PORTLAND MAINE

November 2, 2007

RE: 613 Island Avenue, Peaks Island – 092 E015 – IR-2 – demo existing house and rebuild – permit #07-1310

**FRONT ELEVATION**

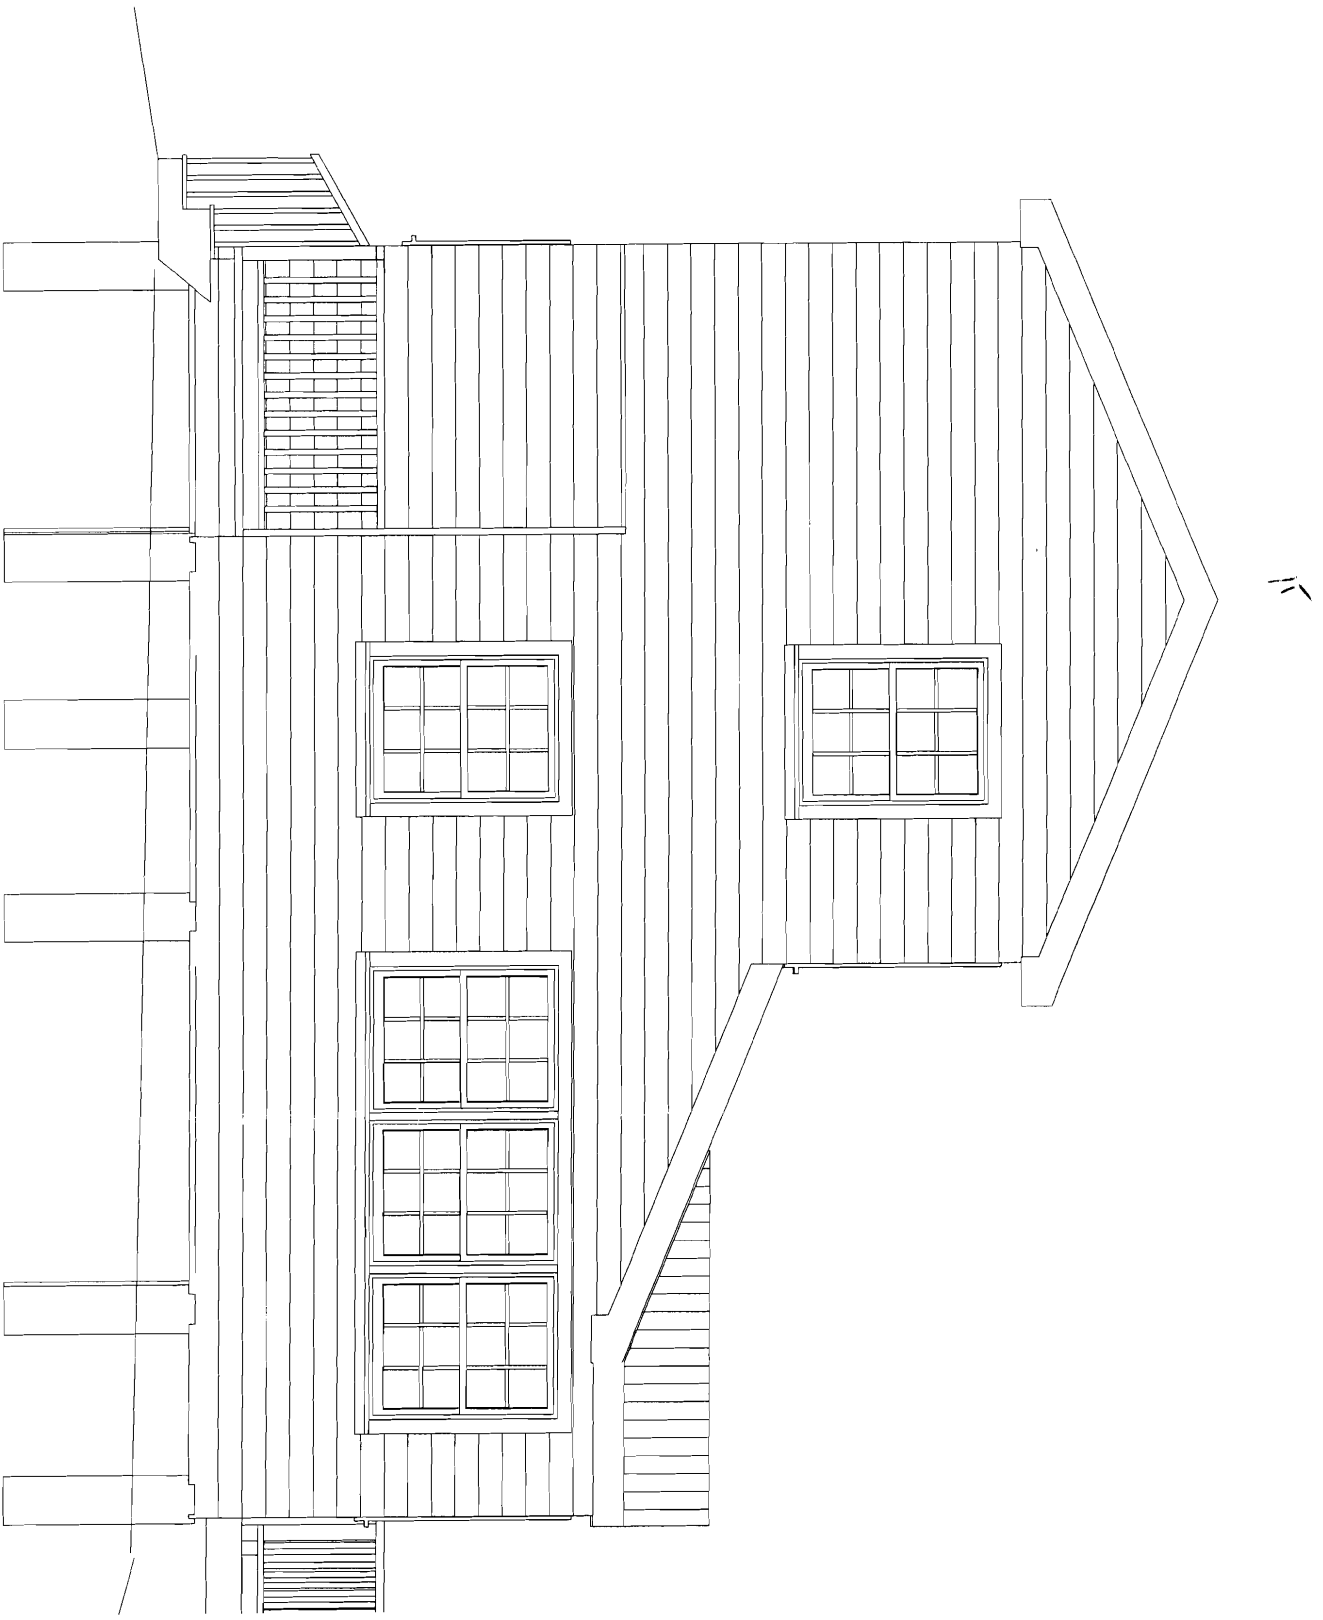
Finally, I need elevation plans for the rear and right side of the proposed structure and a cross section that shows how much living space is being added to make sure that the increase does not exceed the allowable 50%.
